Our Ref: Y/93/19/DOC

Approval of details reserved by condition imposed under ref Y/47/19/HH relating to Condition No 4 - proposed surface water drainage.

Normandie Church Lane Yapton BN18 0EH

Arun District Council have decided to **REFUSE details reserved by condition for the following reasons:**

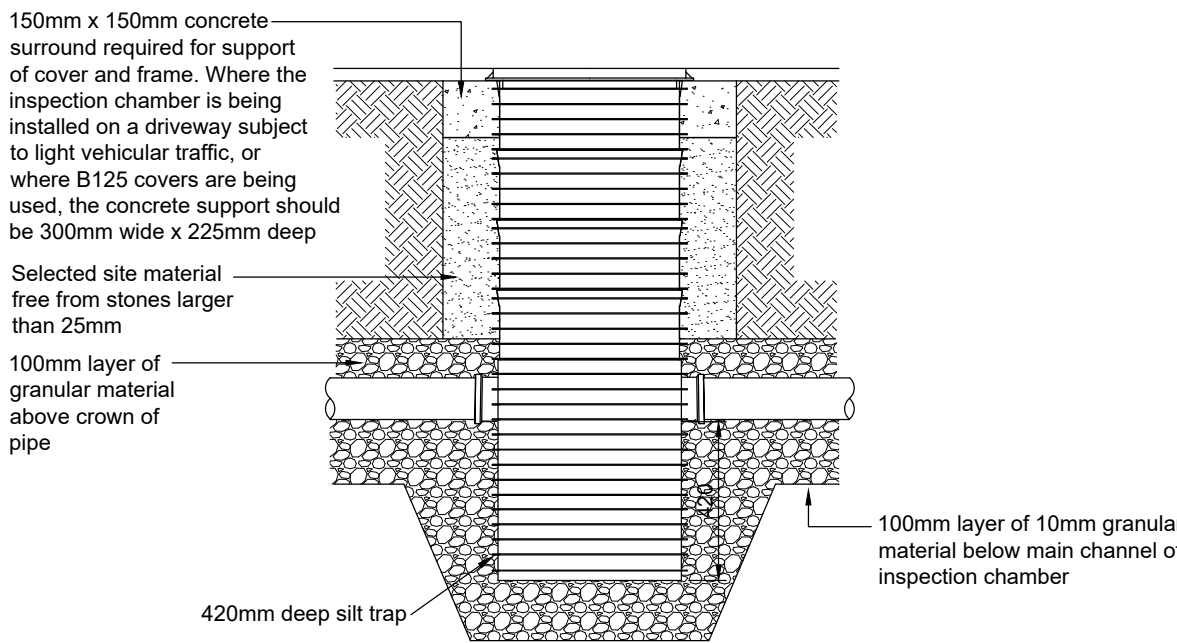
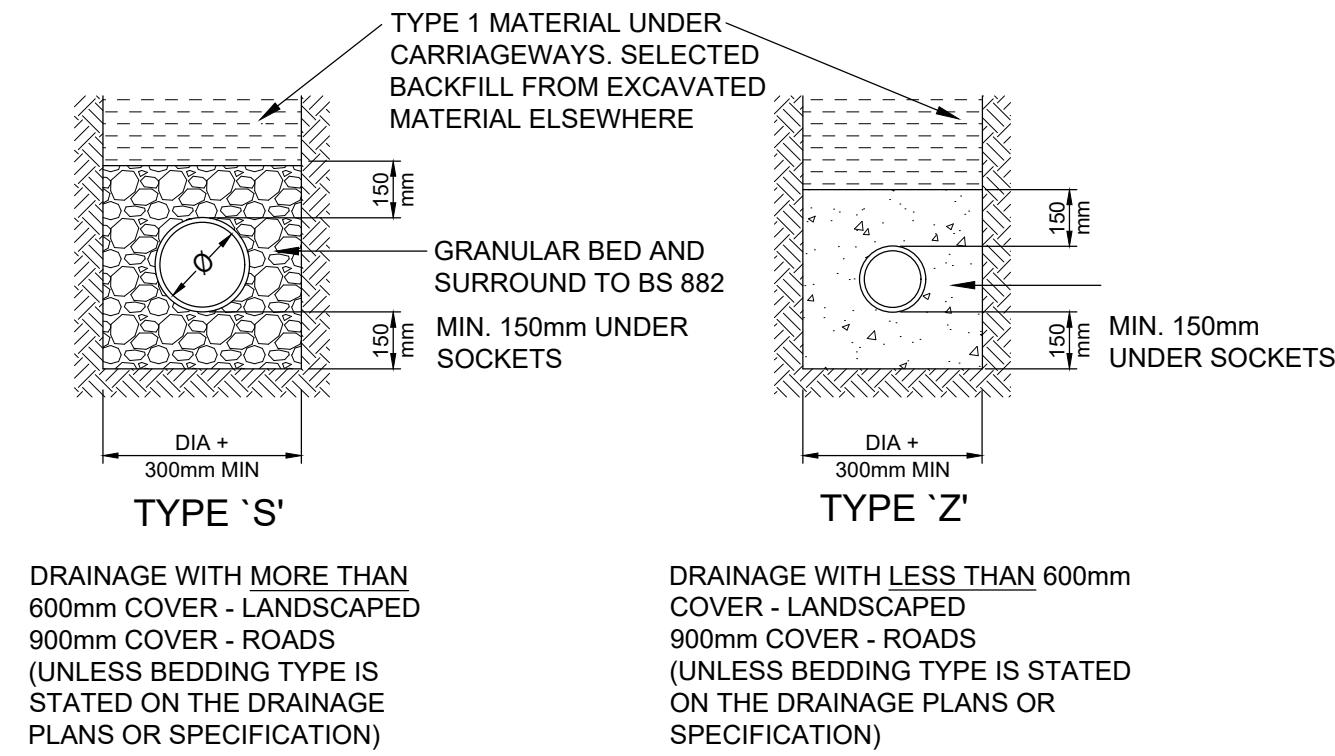
The condition cannot be discharged at this time. In order for the condition to be discharged, repeat testing will have to be completed in the winter period, (generally accepted to be December to March). Please also ensure that your trial pit is in accordance with the dimensions dictated by BRE365.
